Date: 09-Jul-2026
Our Ref: 2026/90696

PRIOR APPROVAL FOR ALTERATIONS TO BRIDGE MVL3/71
BRIDGE MVL3/71, BRITANNIA ROAD, MILNSBRIDGE, HUDDERSFIELD, HD3 4QF
APPLICATION NO: 2026/90696

The Council considers that the works detailed in the above application are permitted development under Part 18(A) of Schedule 2 of the Town and Country Planning (General Permitted Development) (England) Order 2015 and that Prior approval for the development is hereby granted subject to the following conditions:

Drawing Title
**Prior Approval -
MVL3/71 Britannia Road, Golcar
Existing & Proposed Elevations**

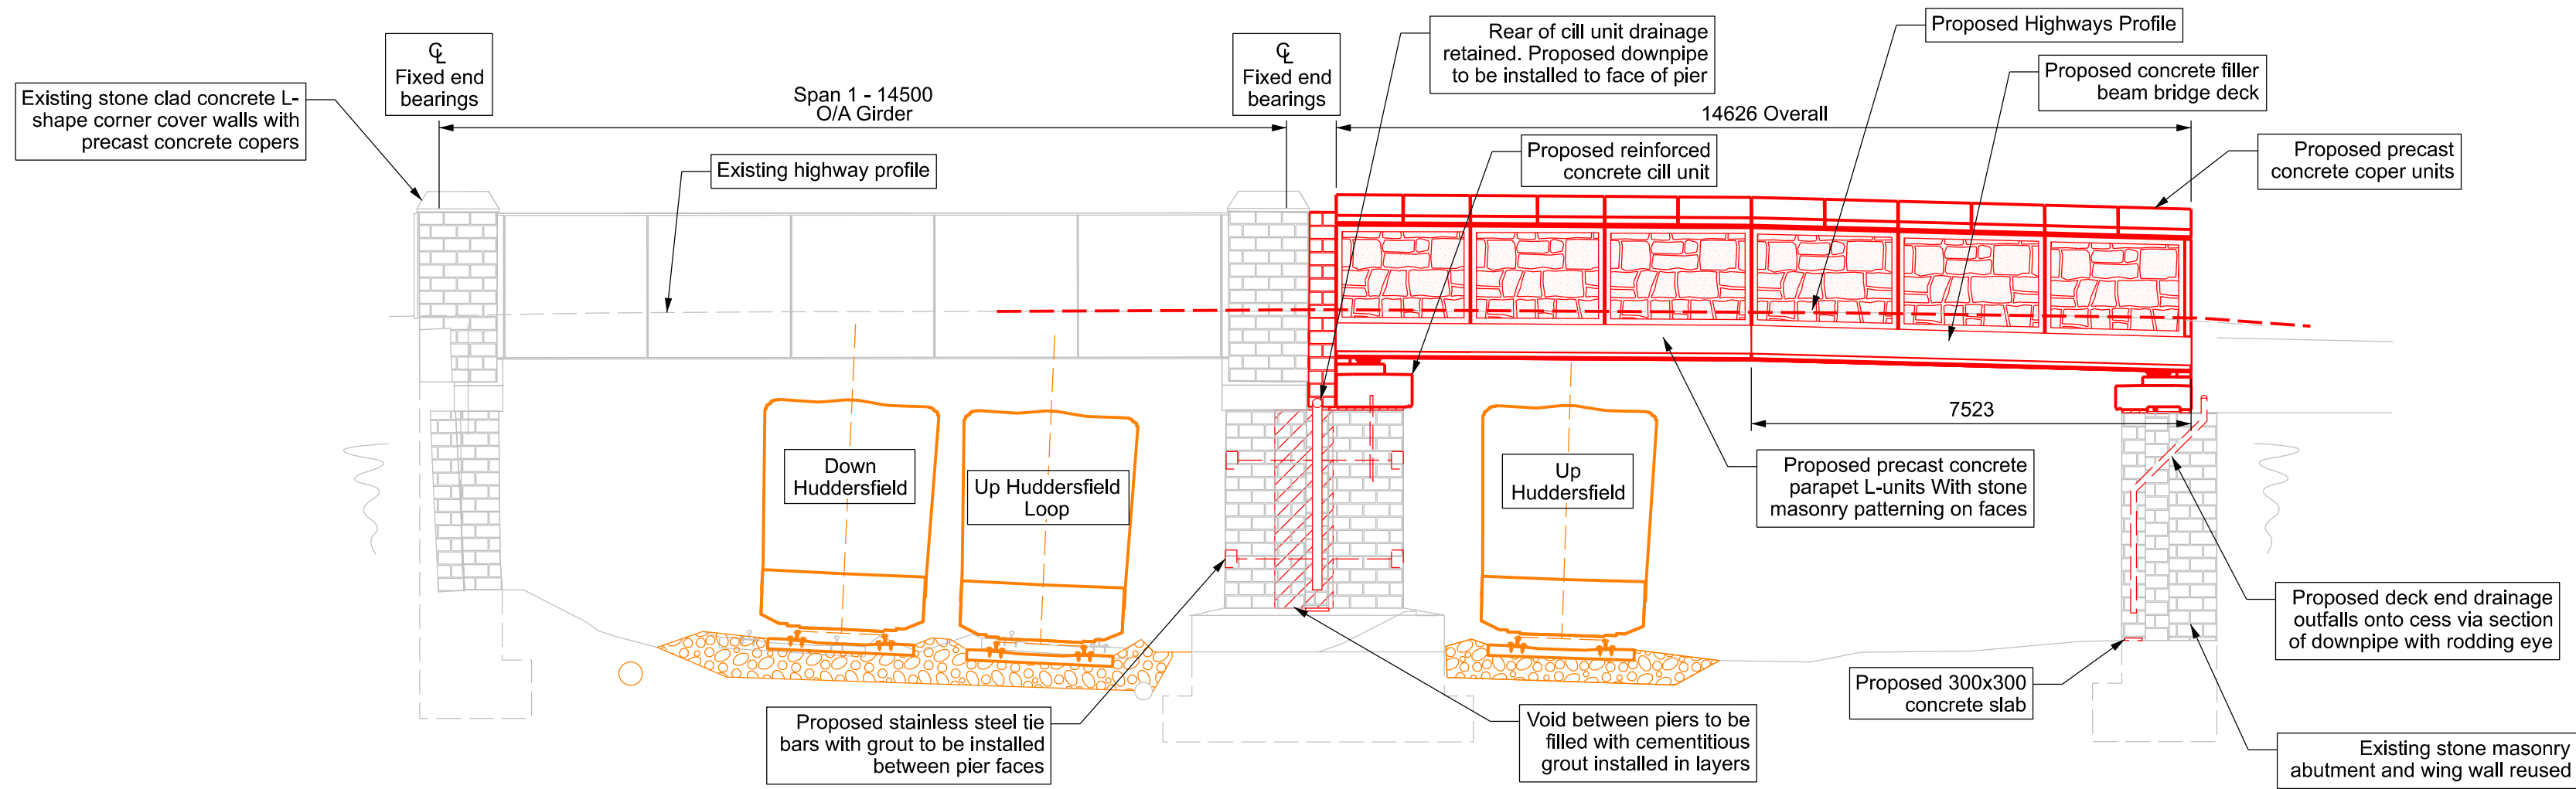
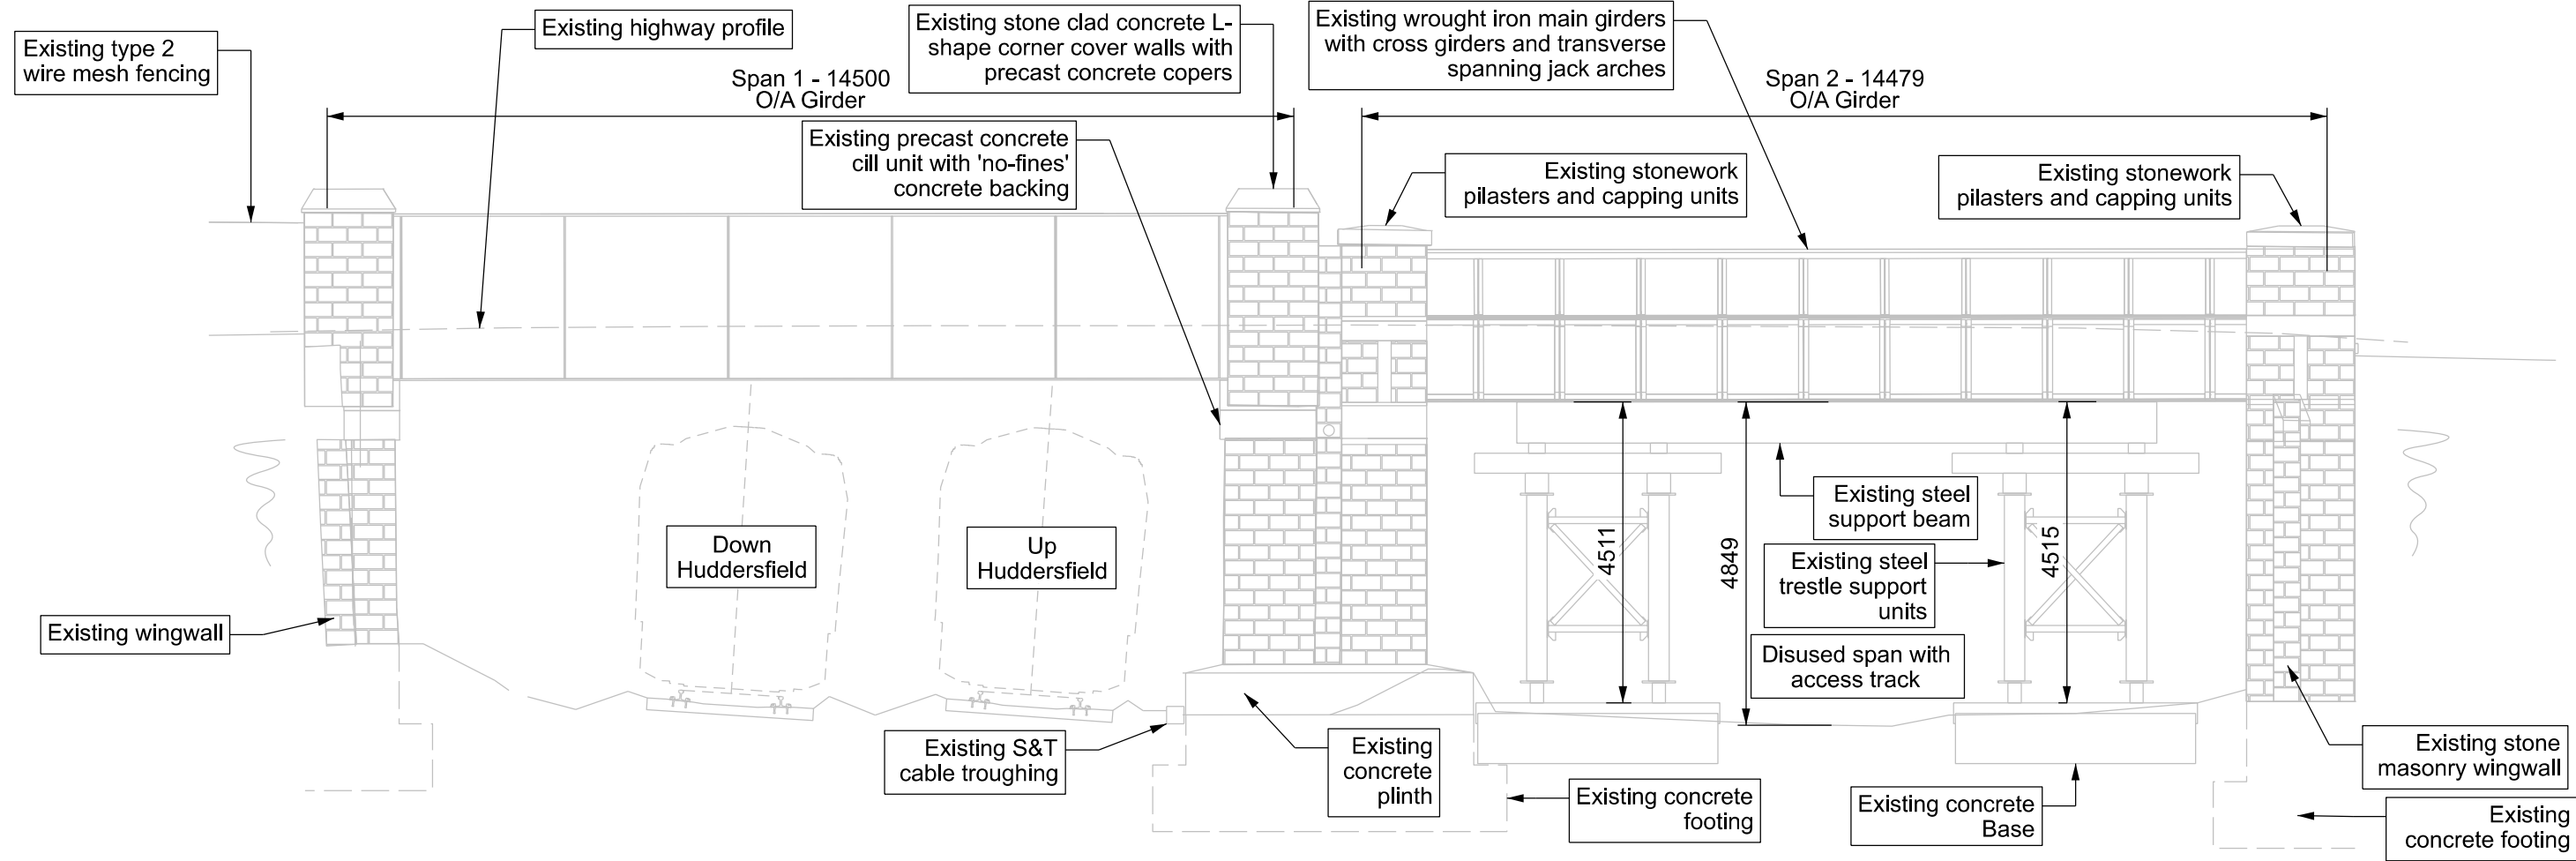
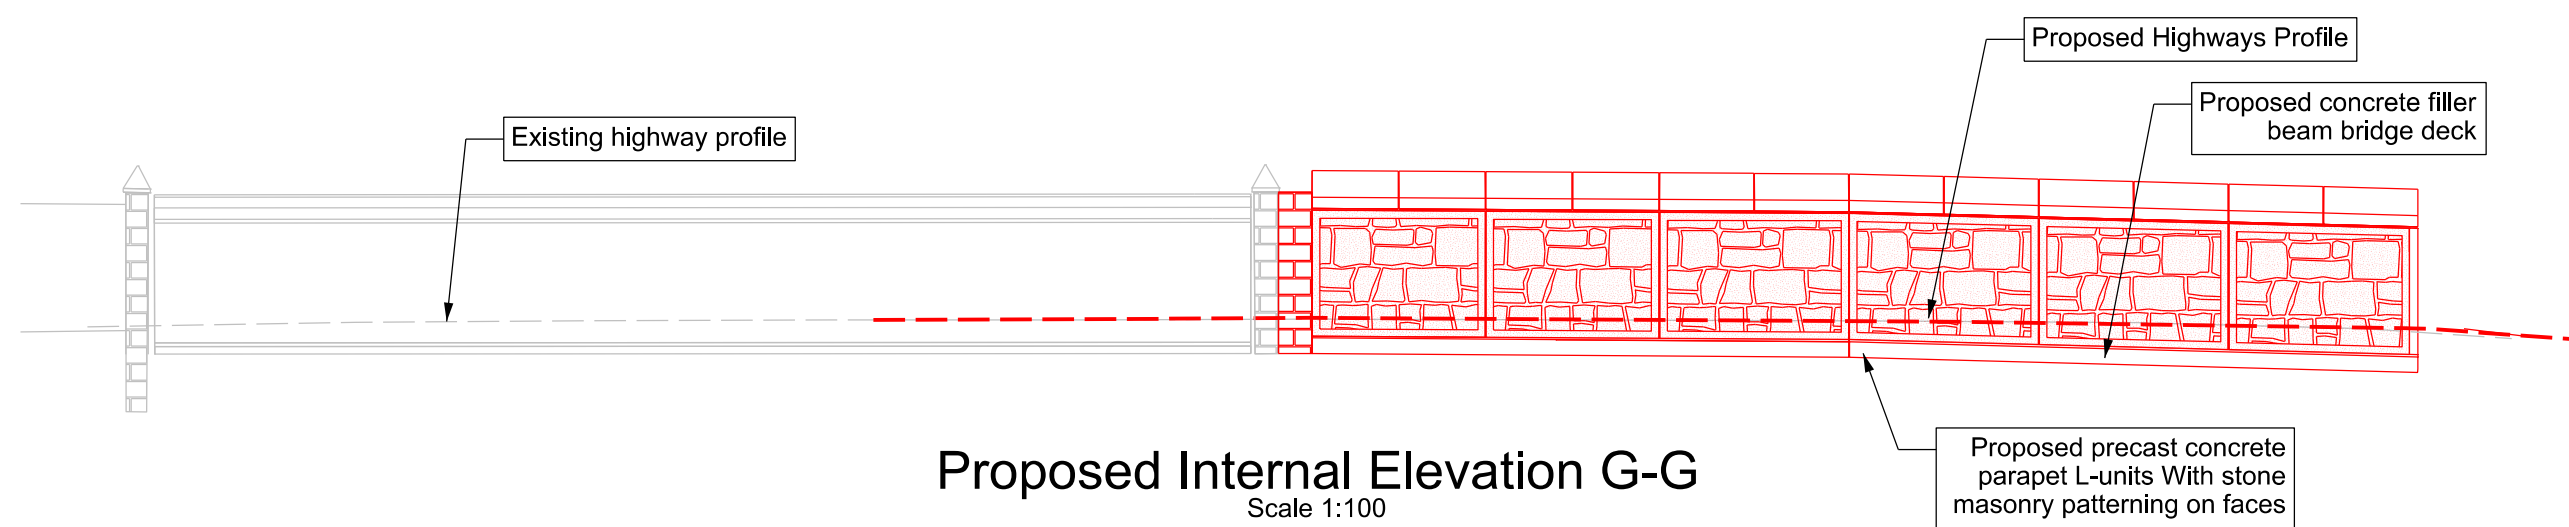
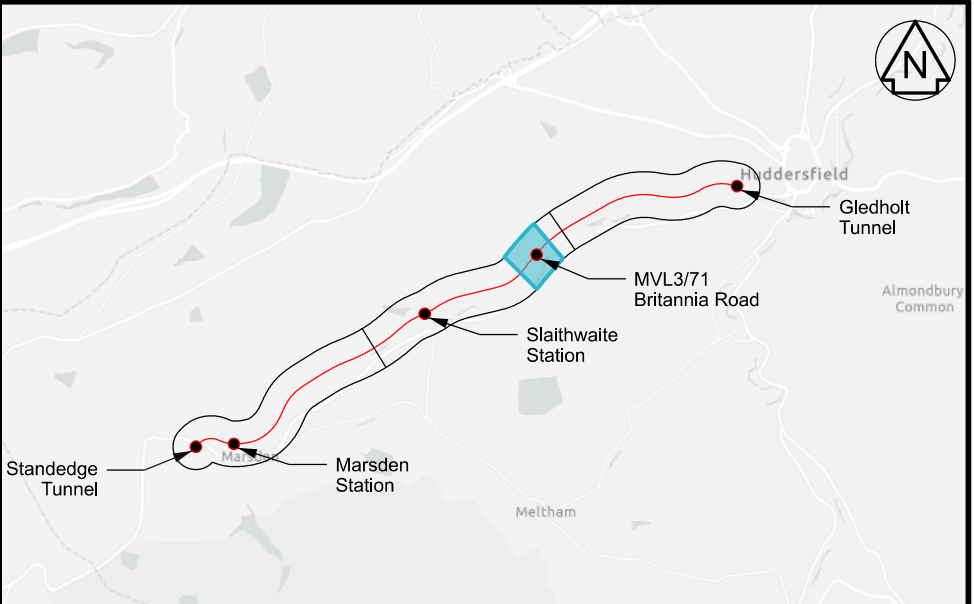
1. Notwithstanding the submitted plans, a sample of the parapet finish[es] shall be submitted to and approved by the Local Planning Authority, prior to their installation. The external treatment of the parapet finish[es] shall reflect the retained stonework of the bridge in terms of colour, texture, finish and coursing.
